UDON, PPR-24-22

Please accept the following comments from El Paso County Public Health for the plot plan review request referenced above:

POND PLAN
 SHEET 9 OF 20

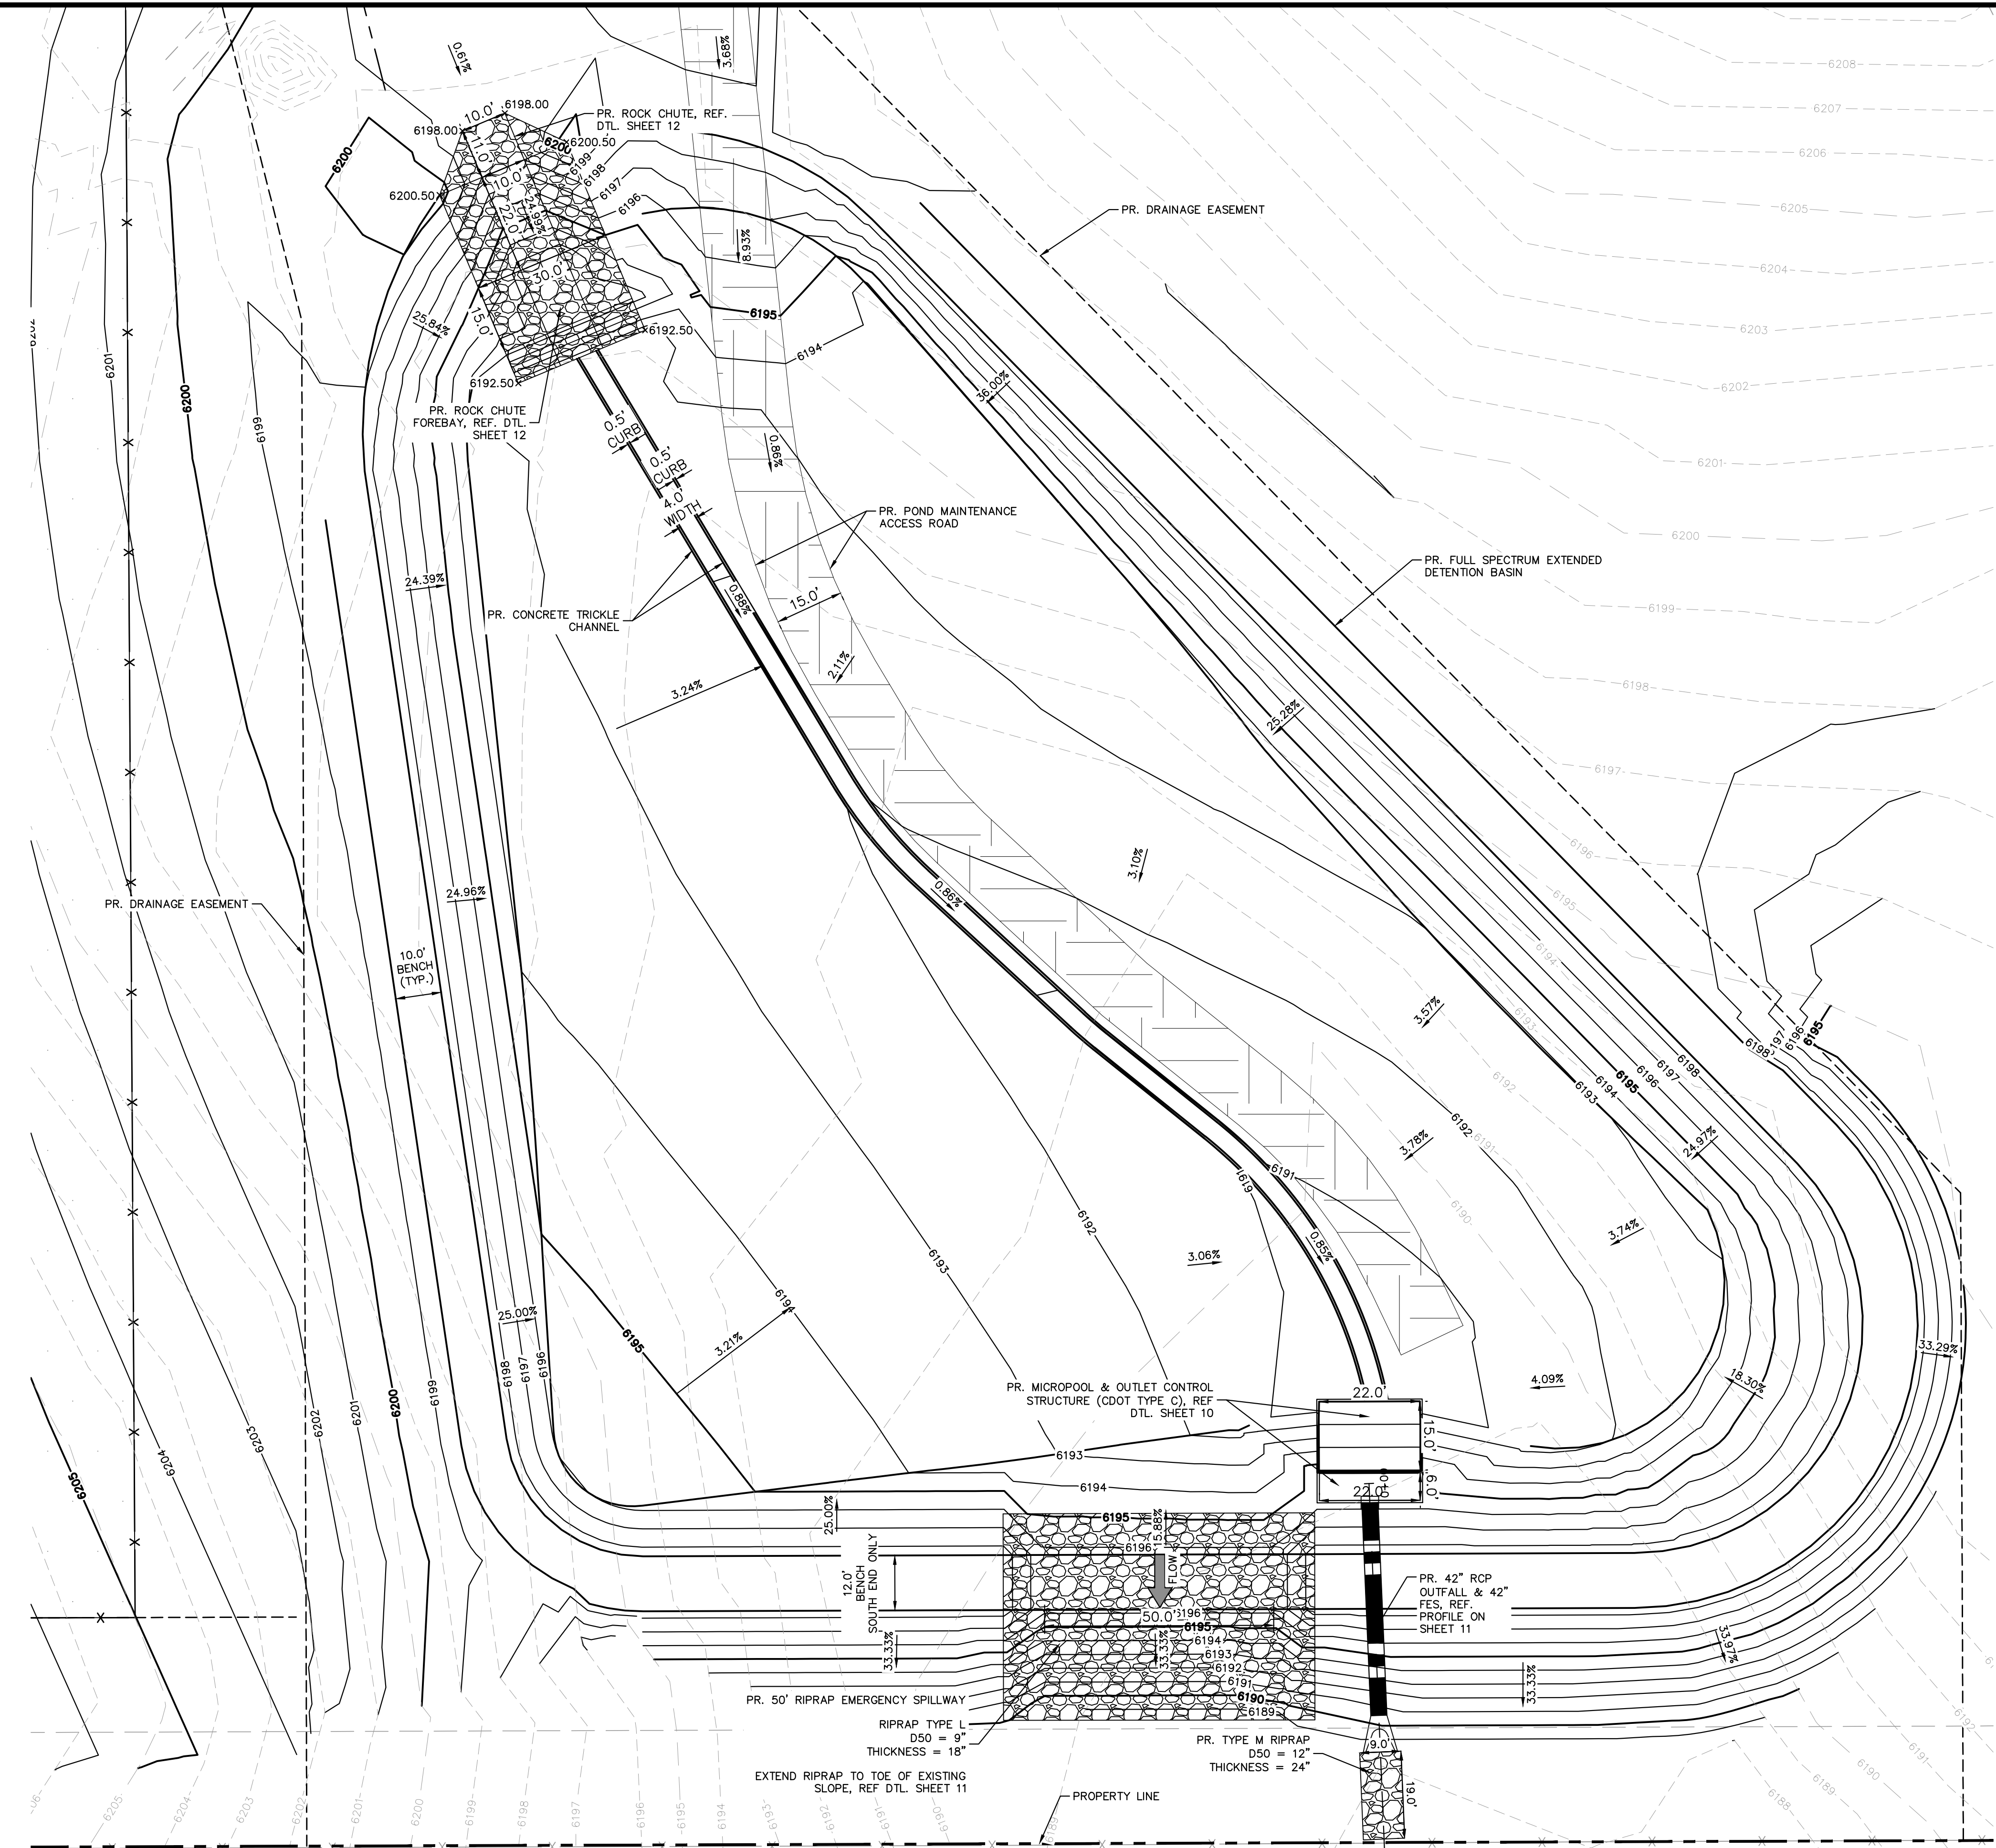
- The water quality basin must have mosquito control responsibilities included as a part of the construction design and maintenance plan to help control mosquito breeding habitat and minimize the potential for West Nile Virus.
